KITTITAS COUNTY COMMUNITY DEVELOPMENT SERVICES

October 4, 2022

**Subject: Suncadia Phase 2 Division 8 (LP-22-00005) Preliminary Plat
– Staff Review and Deemed Incomplete**

Site Development Plan Phase 2 Division 8

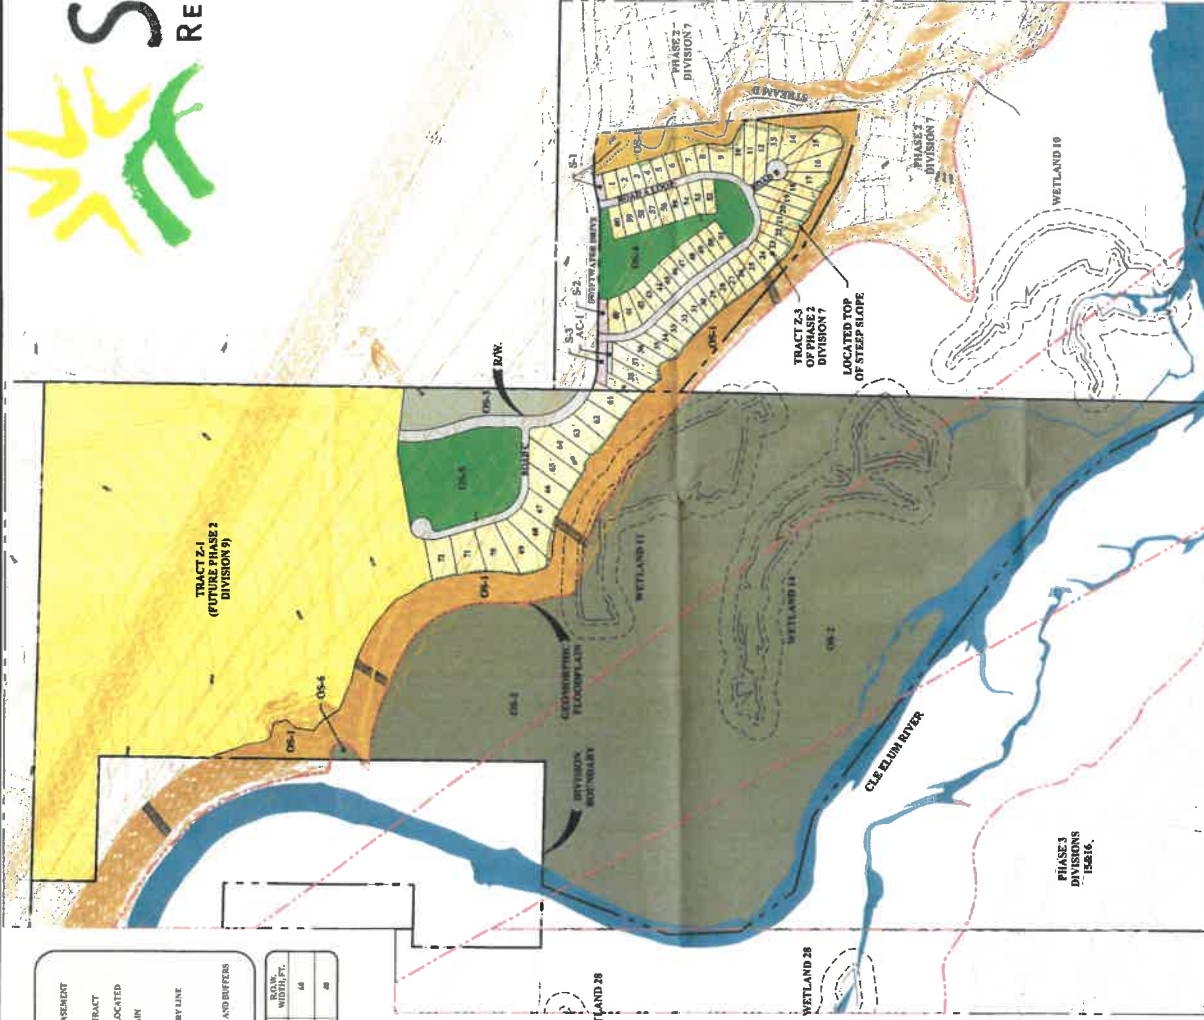
- Tax Map Number 20-11-11000-0013 is showing as a retired parcel number. The Assessor's data is showing this parcel must be sold with 20-14-11000-0005, which is not identified on the application. Please verify parcels with the County's parcel data and update the application as needed.
- Total Acreage identified within the application is showing as 290.3 acres. When calculating the acreage through Tax Sifter I am totaling 329.63 acres, including the Must be sold with lot mentioned above. Please verify the parcel acreage with the County's Parcel data and update the application as needed.
- The project narrative (2)(i) states that the project will have lake amenities. The Site Development Plan submitted does not show lake amenities. CDS is asking for clarification in this regard.
